CITY OF ALBUQUERQUE

May 9, 2019

RE: 8500 Glendale Ave. NE
Grading and Drainage Plan
Engineer's Stamp Date: 04/25/19
Hydrology File: B20D067

City Project No. **B20D067** Zone Map No. Sheet **1** Of **3**

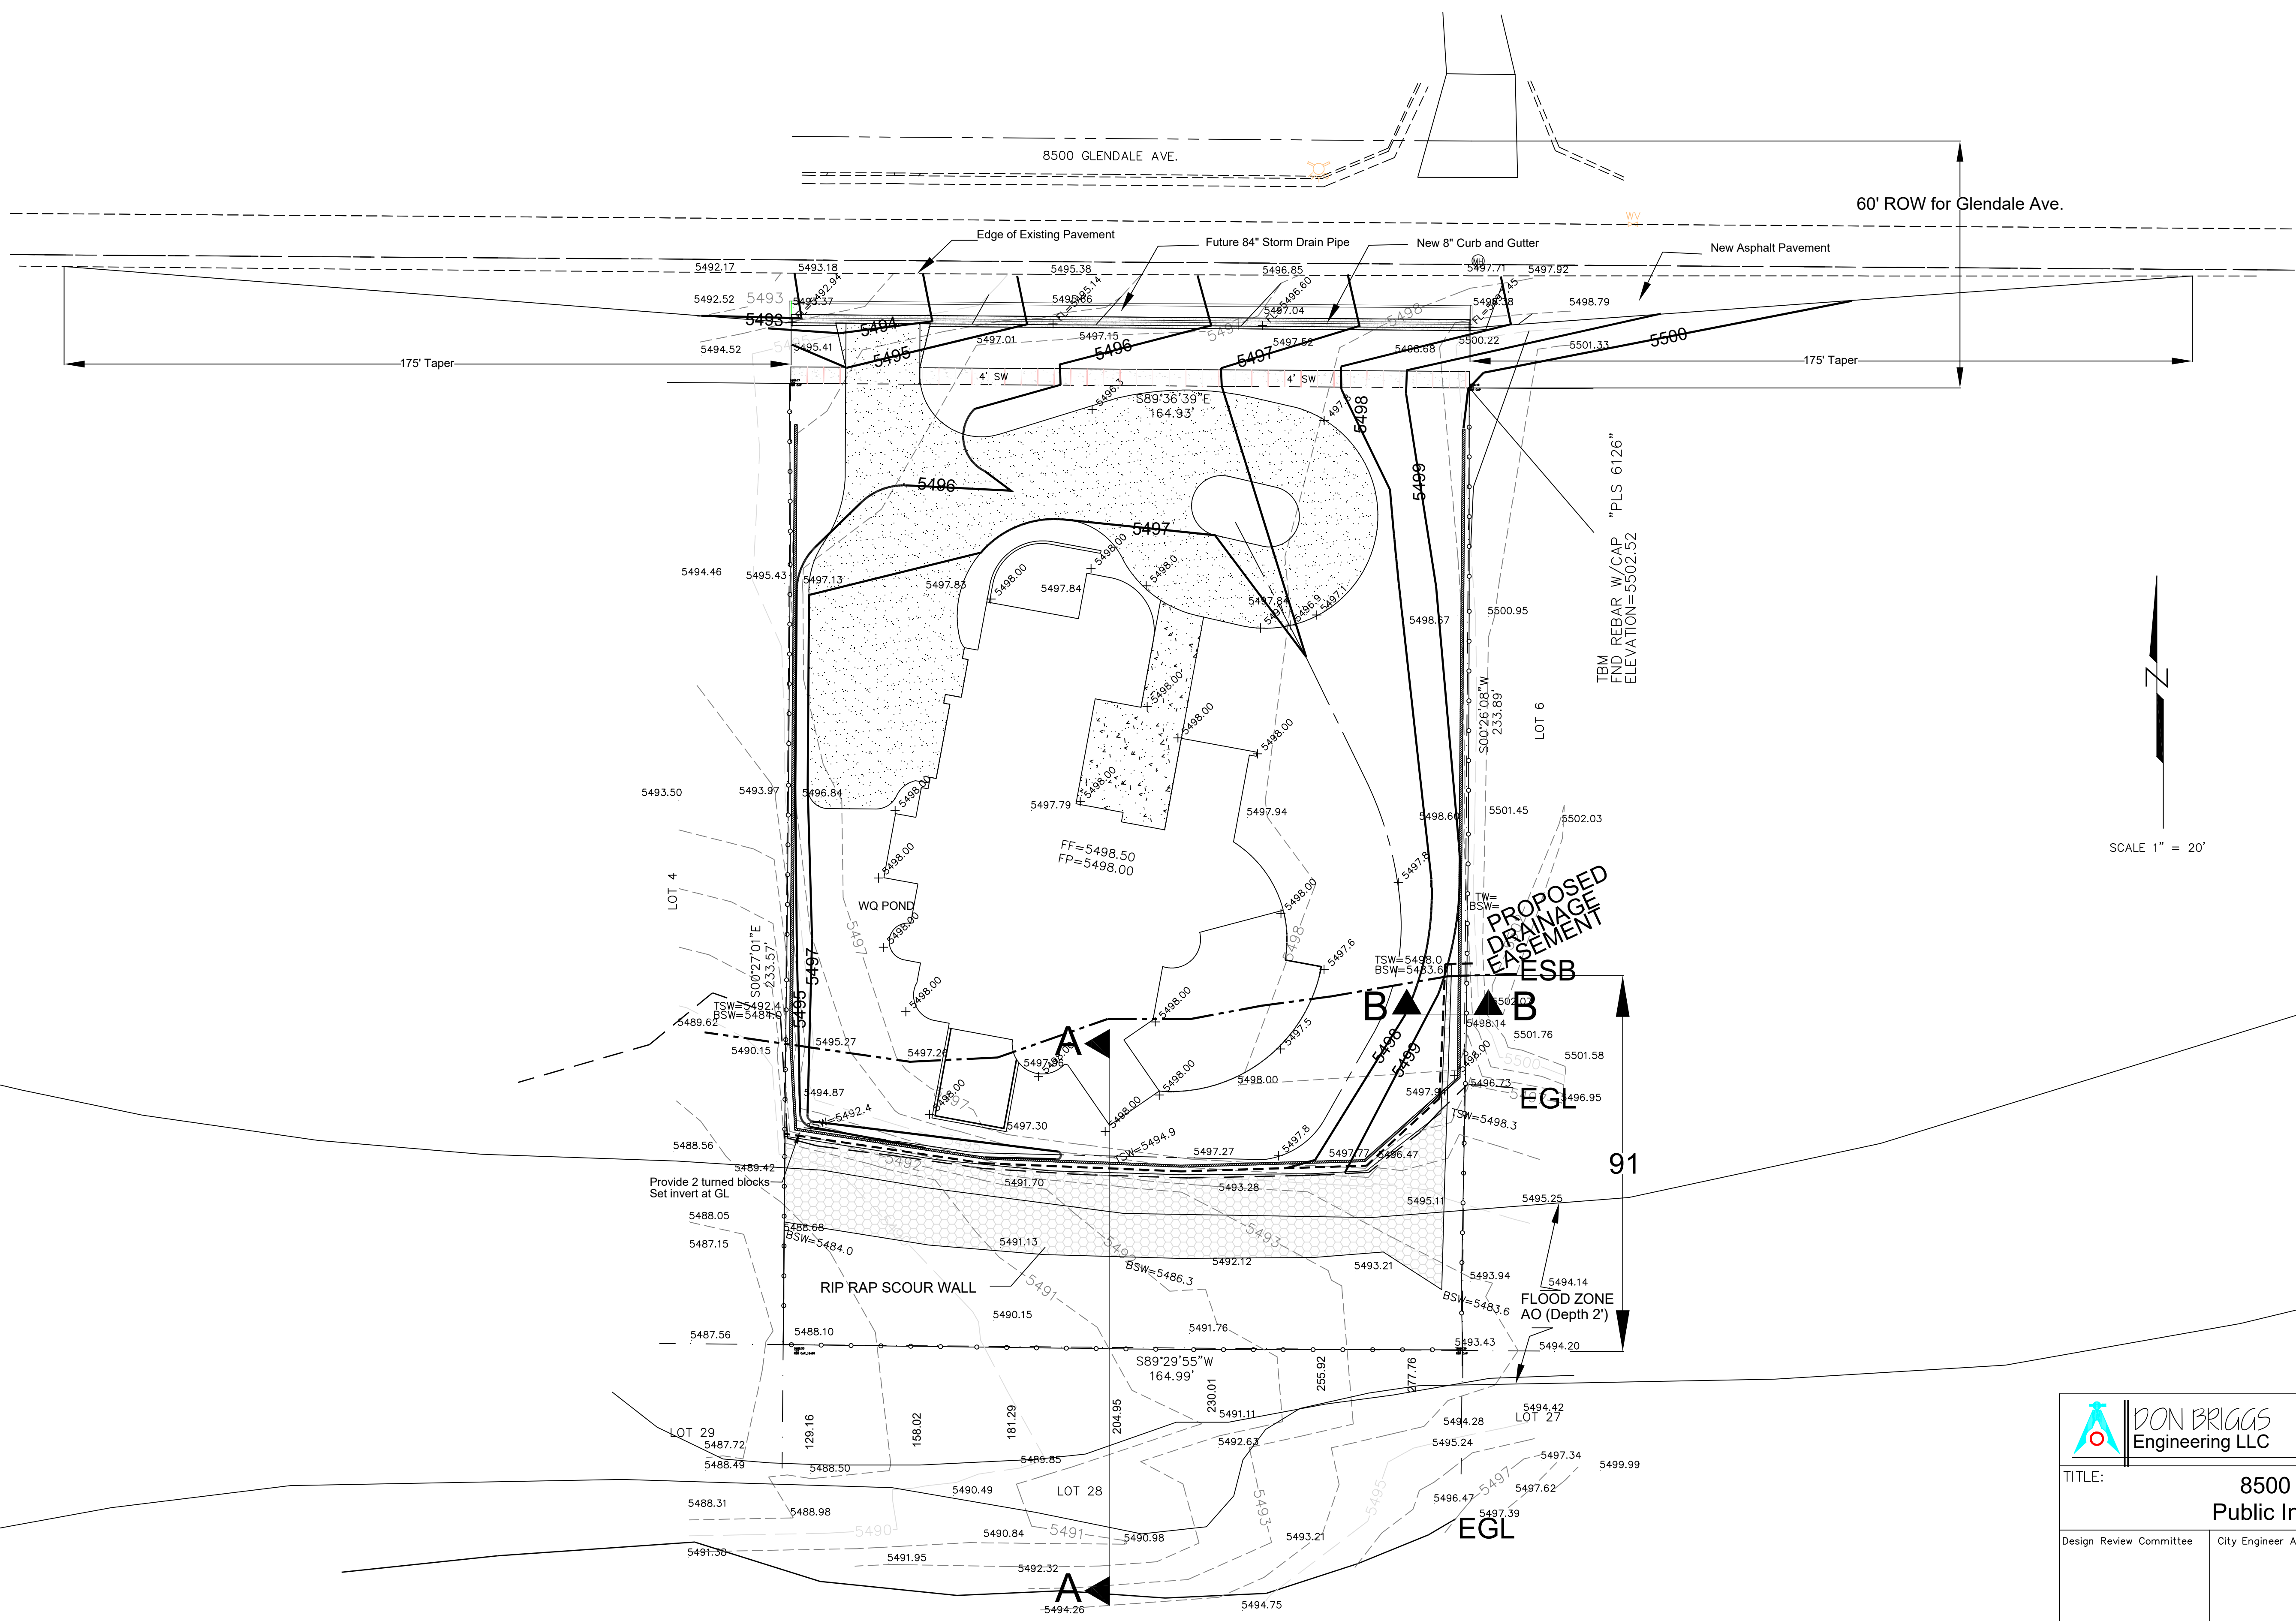
3. Please also ensure that all linetypes are either labeled or in the Legend.
4. At the northwest corner of the property, there is proposed grating on the adjacent property. A written approval from the adjacent property owner is required prior to Building Permit approval.

5. Per DPM Ch. 22.5.B, grading and construction of retaining walls at or near the property line must demonstrate that the adjacent property is not damaged or its use constrained. Any such encroachment by the wall or grading must be accompanied by written permission of both landowners. Wall footer cannot extend over the property line.

9. Please label the R.O.W. (Glendale Ave.).
10. Please label the existing edge of pavement within the R.O.W.
11. Please clarify what is being proposed within the R.O.W. There are multiple lines without any labels. Per the IDO § 6-4(Q), the property owner of the property is responsible for building the adjacent half of Glendale Ave to include curb & gutter, sidewalk, and 84" storm sewer per the North Albuquerque Acer Master Drainage Plan. The plan will have to go to the DRB for approval of the Infrastructure List which will have to financially guaranteed.

13. Please remove the scour wall along the West property line. This is not needed since the arroyo cannot expand at more than a 3:1 angle.
14. The western edge of the riprap needs to be thickened to prevent erosion. Please add a note.

17. Please provide the digital copy of the HEC-RAS file for our record and review.
18. For the Proposed Drainage Easement shown, please removed the easement line along the western property line. The easement can stop at the property line. The easement along the eastern property line needs to be along the west side of the scour wall to the ESB line and then to the property line.

Concrete Scour Wall 3/8" Pump Mix in 8" wide trench with rebar along east property lines. Extend to ESB

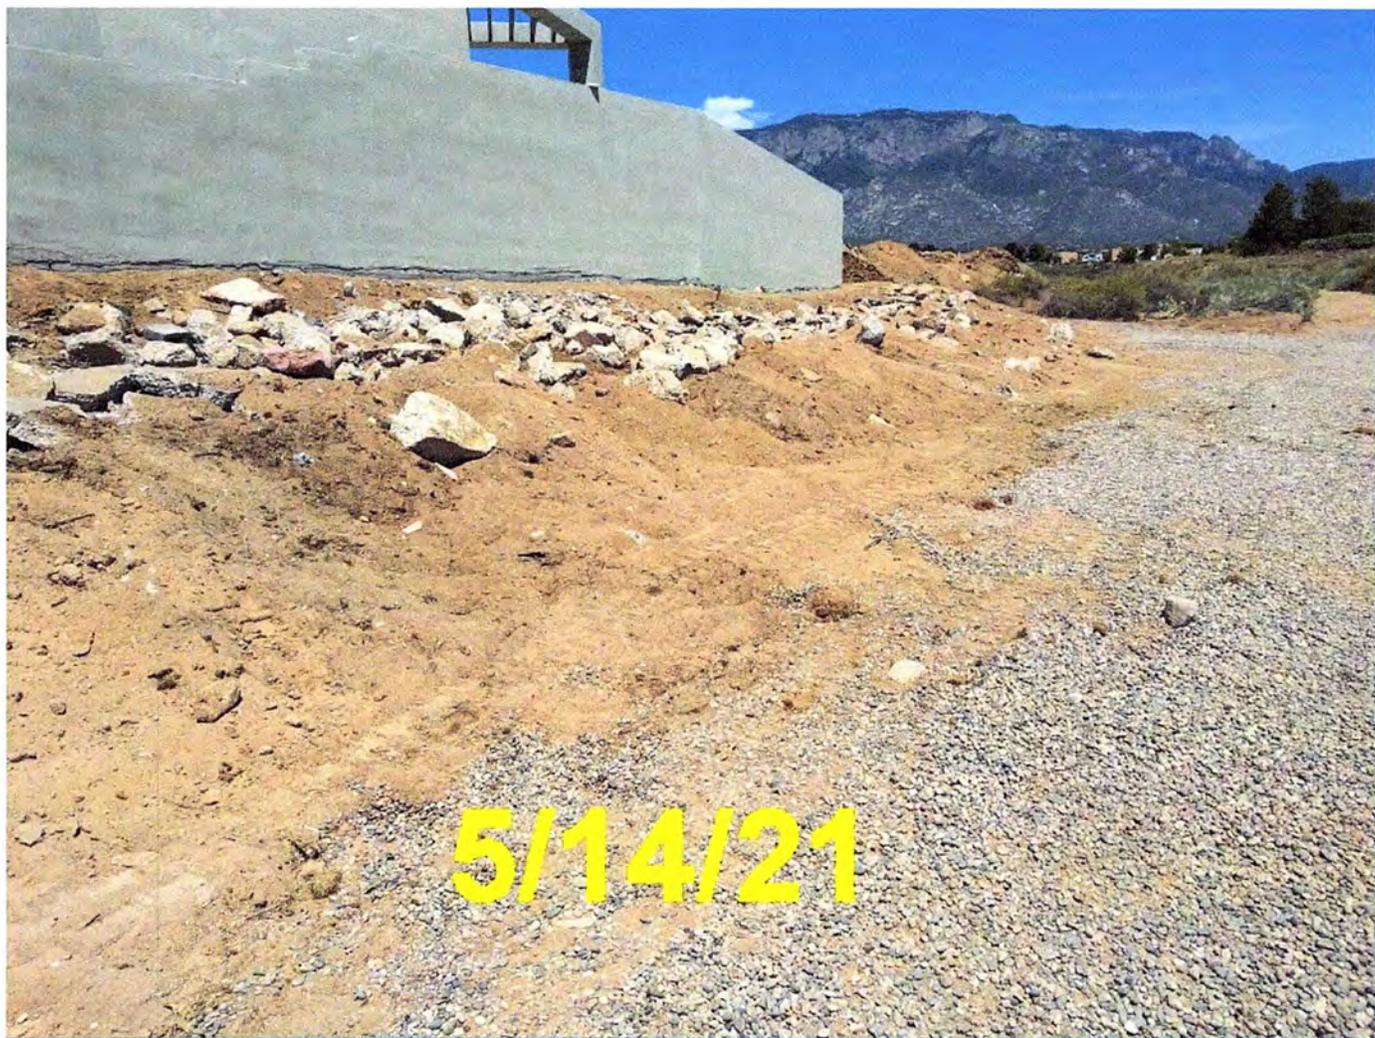
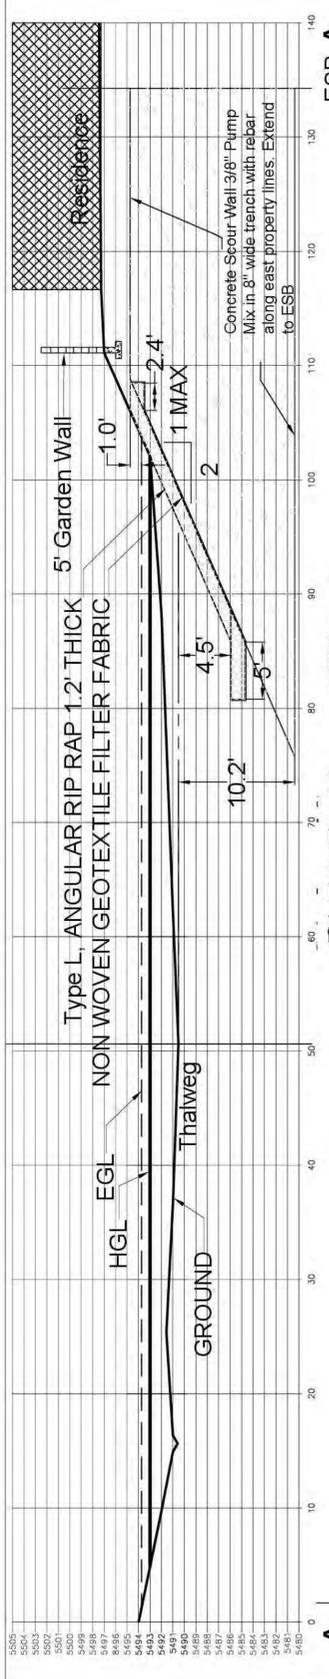
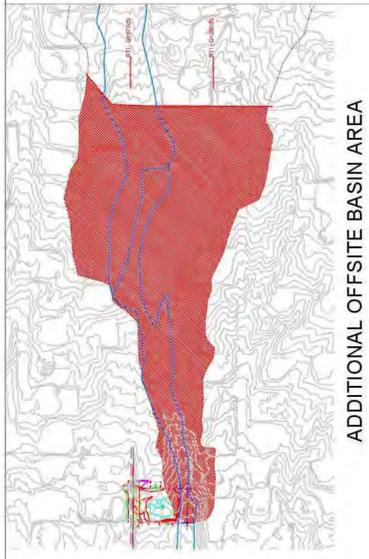
12. Please provide a detail section of the scour wall along the East property lines. This section should include the distance of the proposed wall to the property line and should match the depth requirements from the calculations of 9.15 ft scour depth. This scour wall needs to extend to the southern edge of the riprap.

SCOUR WALL PROFILE
 CHANNEL SLOPE = 0.034 ft/ft

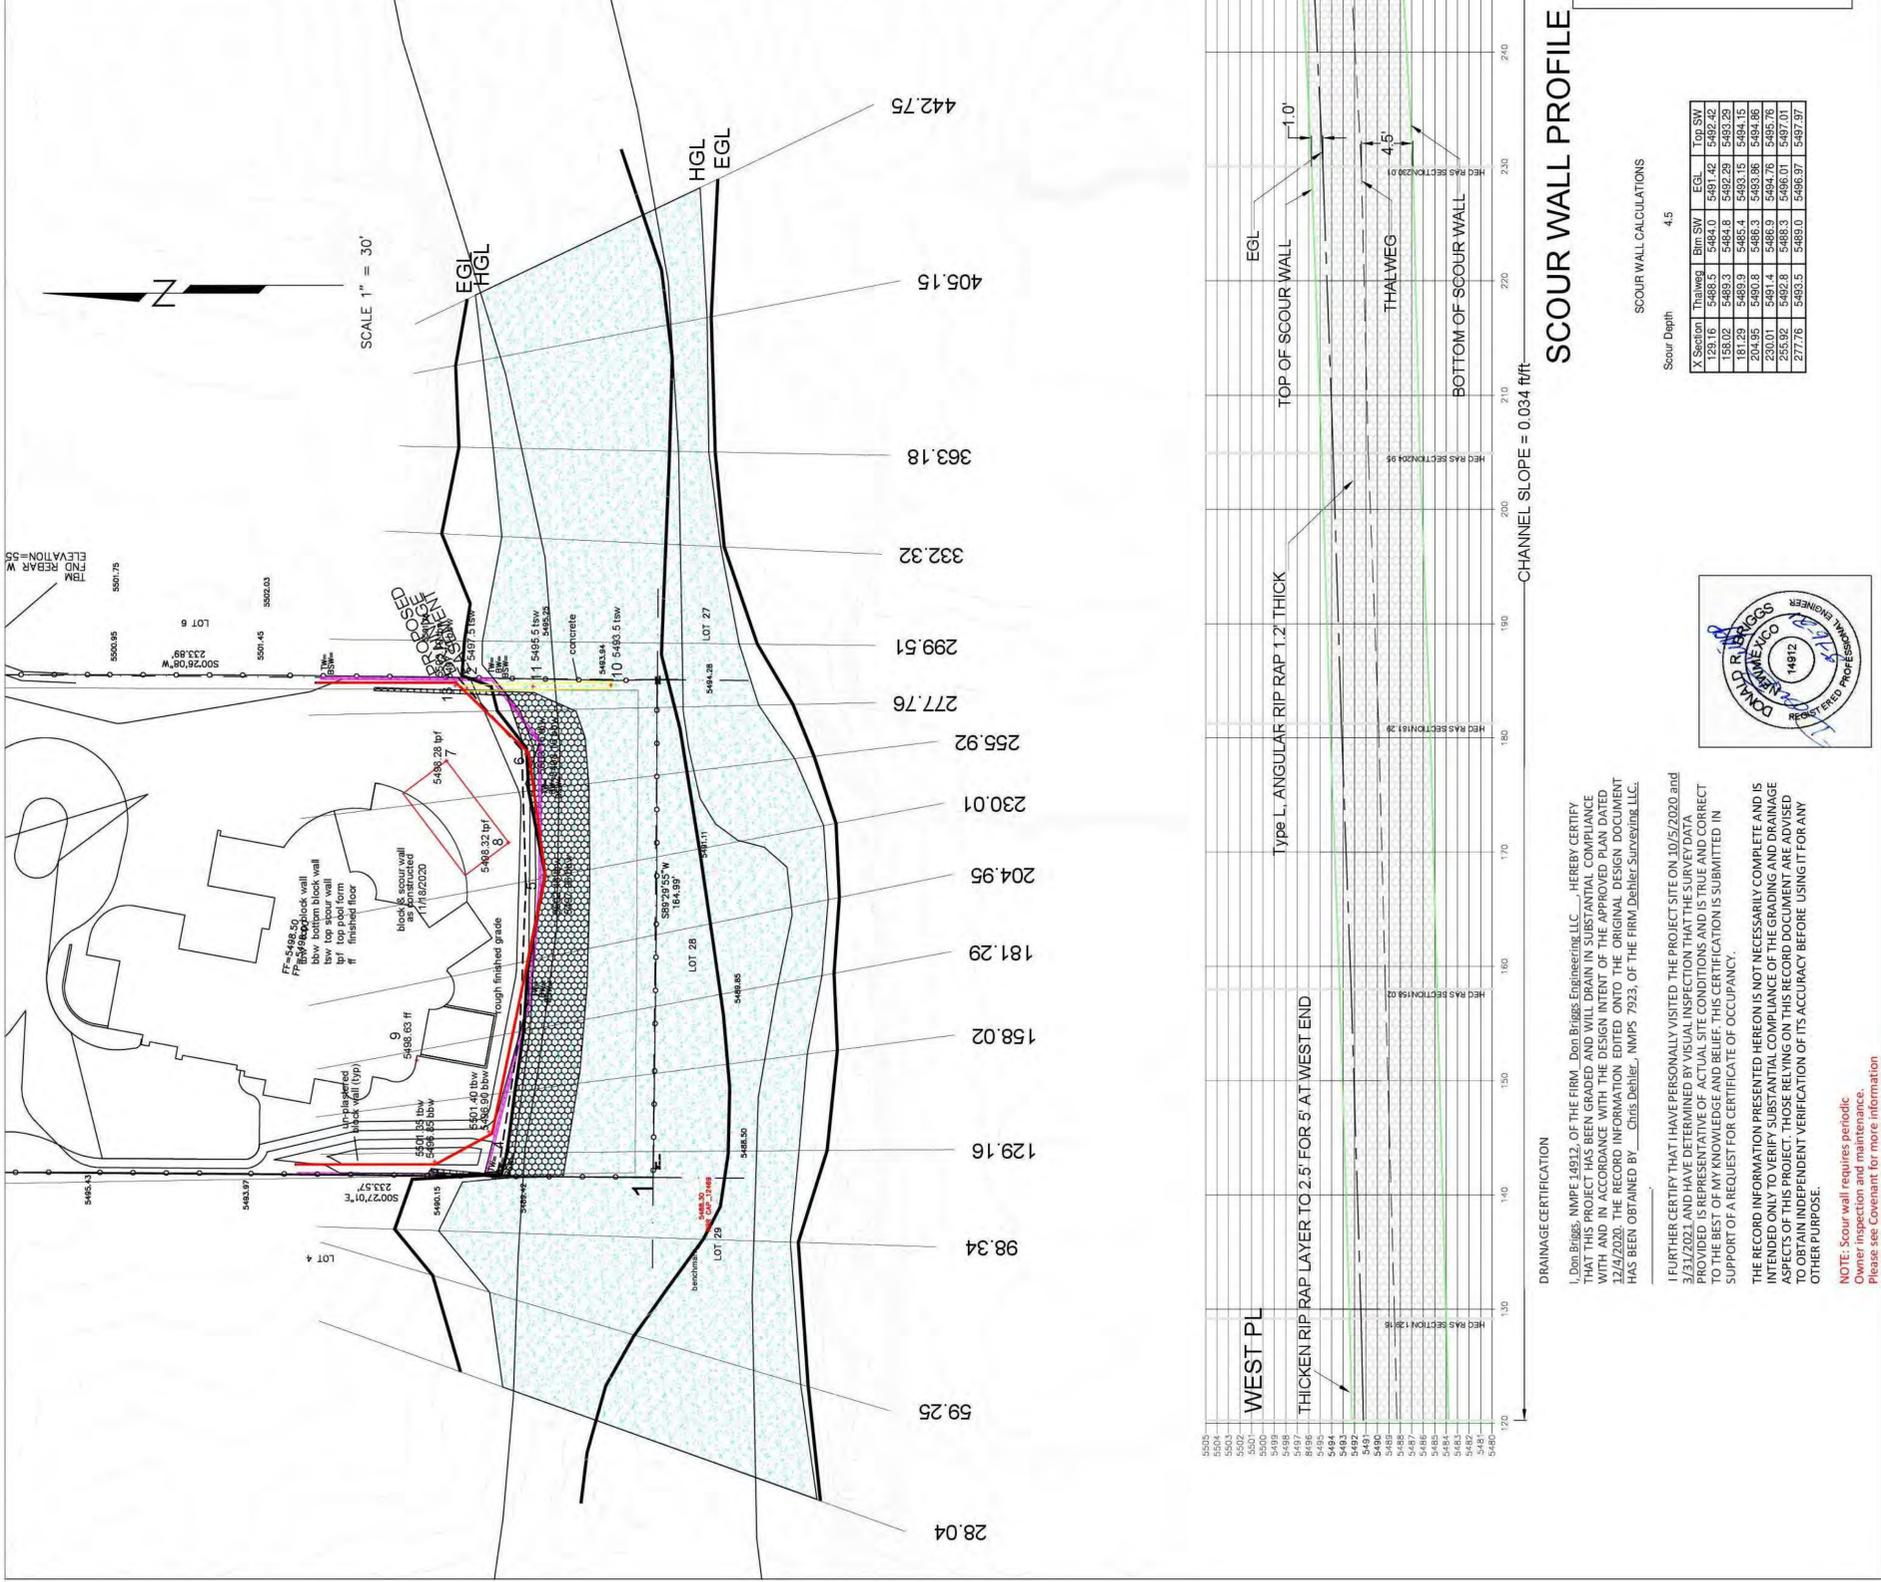
16. Please provide a profile of the riprap along the channel with the average slope, top elevation, bottom elevation, and toe elevation of the channel.
